Subject: Eagle Rising SF2225 Plat Filing 1 Response Letter and EDARP Upload

Our responses to the EPC October 2, 2024, and October 3, 2024 Plat and related documents review comments have been uploaded EDARP.

| EDARP Review Comments | | | | | | | | | | | | | | |
|-----------------------------------------------------|-------------------------------------|--------------------------------------|-------------|--------------------|-----------------|------------------|------|------------------------------------------------------------------------------------------------------------------------------------------------------------------------------------------------------------------------------------------------------------------------------------------------------------------------------------------------------------------------------------------------------------------------------------------------------------------------------------------------------------------------------------------------------------------------------------------------------------------------------------------------------------------------------------------------------------------------------------------------------

EAGLE RISING FILING NO. 1
 A PORTION OF THE EAST HALF (E1/2) OF SECTION 29, TOWNSHIP 12 SOUTH,
 RANGE 65 WEST OF THE SIXTH PRINCIPAL MERIDIAN, EL PASO COUNTY, COLORADO

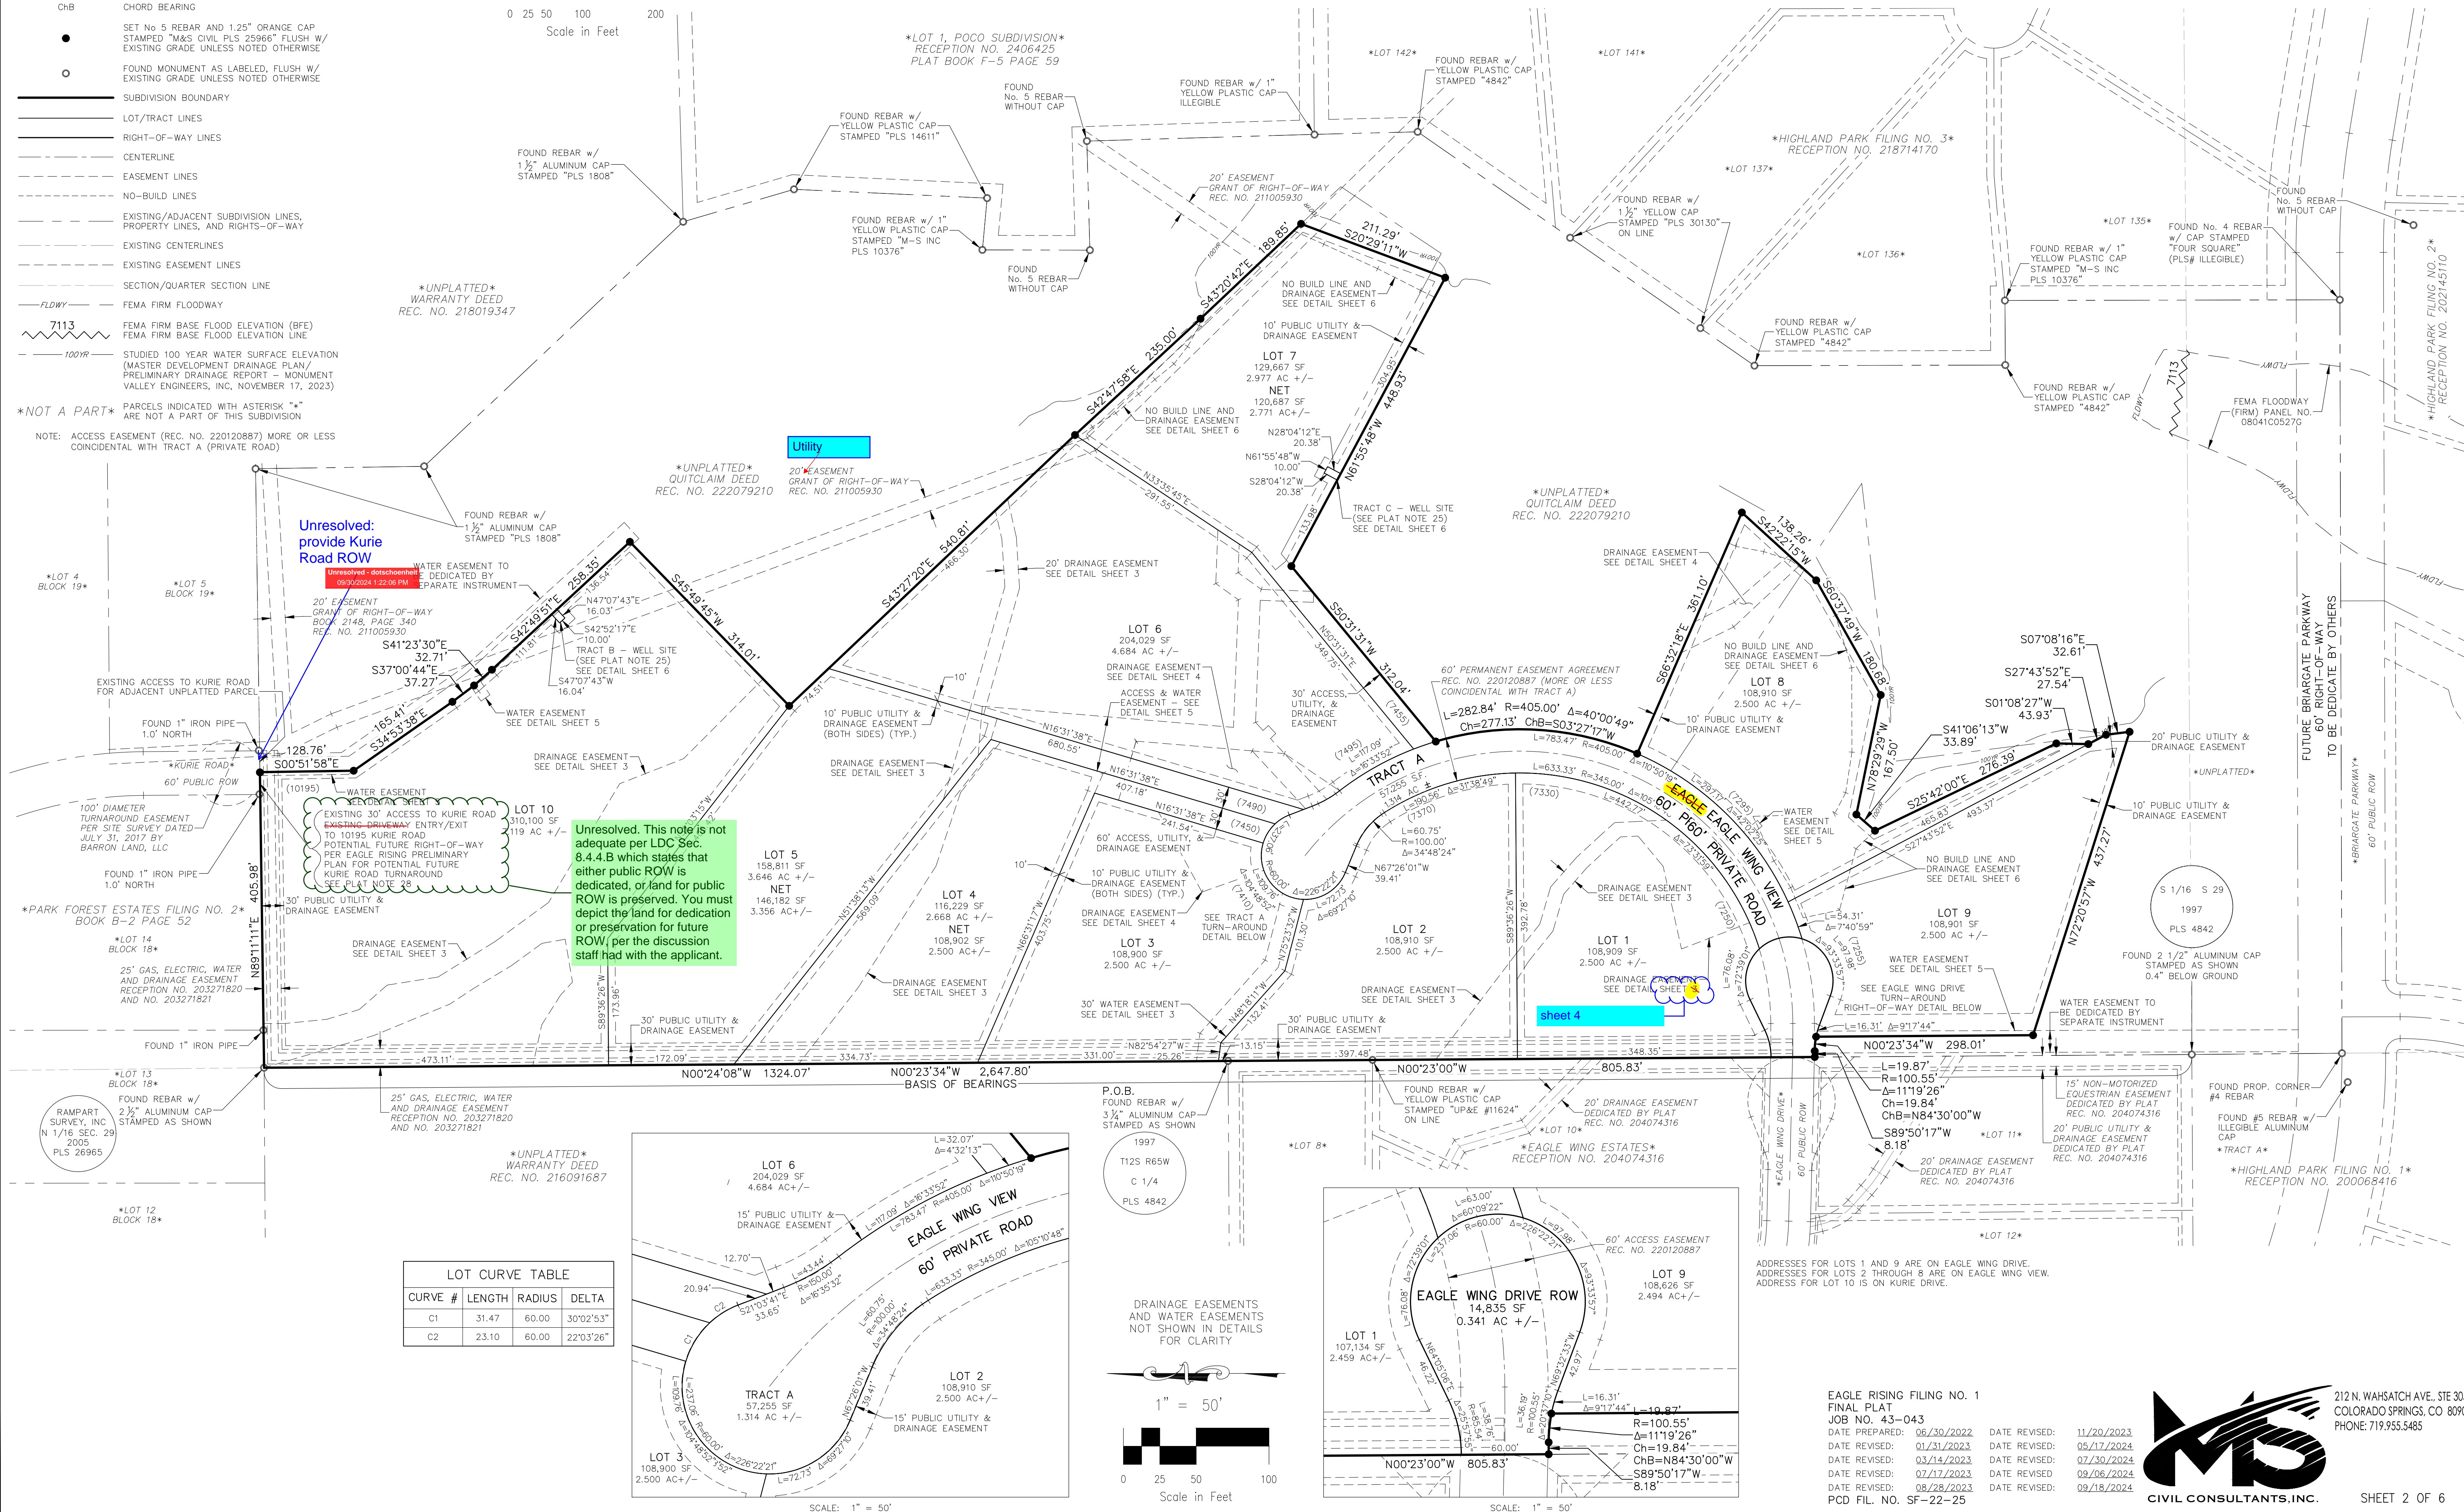
| EDARP Review Comments | | | | | | | | | | | | | | |
|-----------------------------------------------------|-------------------------------------|--------------------------------------|-------------|--------------------|-----------------|------------------|------|----------------------------------------------------------------------------------------------------------------------------------------------------------------------------------------------------------------------------------------------------------------------------------------------------------------------------------------------------------------------------------------------------------------------------------------------------------------------------------------------------------------------------------------------------------------------------------------------------------------------------------------------------------------------------------------------------------------------------------------------------------------------------------------------------------------------------------------------------|------------------------|-------------------------|-------------------------------------|------|--------------------------------------------------------------------------------------------------------------------------------------------------------------------------------------------------------------------------------------------------------------------------------------------------------------------------------------------------------------------------------------------------------------------------------------------------------------------------------------------------------------------|--------------------------------------------------------|
| 8 | Final Plat Eagle Rising Filing No 1 | PCD Engineering Division | Yes | Edward Schoenheit | 10/3/2024 10:53 | (Plat redlines) | 2 | Unresolved: provide Kurie Road ROW | C - Disapproved | 10/21/2024 | Final Plat Eagle Rising Filing No 1 | - | Disagree There is only one lot, Lot 10 (existing house at 10195 Kurie Road), accessing Kurie Road on Eagle Rising Final Plat Filing No. 1. See comment response #7, #9, #10 | |
| 9 | Final Plat Eagle Rising Filing No 1 | PCD Project Manager | Yes | Ryan Howser | 10/3/2024 10:53 | (Plat redlines) | 2 | Unresolved. This note is not adequate per LDC Sec. 8.4.4.B which states that either public ROW is dedicated, or land for public ROW is preserved. You must depict the land for dedication or preservation for future ROW, per the discussion staff had with the applicant. | C - Disapproved | 10/21/2024 | Final Plat Eagle Rising Filing No 1 | - | Disagree There is only one lot, Lot 10 (existing house at 10195 Kurie Road), accessing Kurie Road on Eagle Rising Final Plat Filing No. 1. See comment response #7, #8, #10 | |
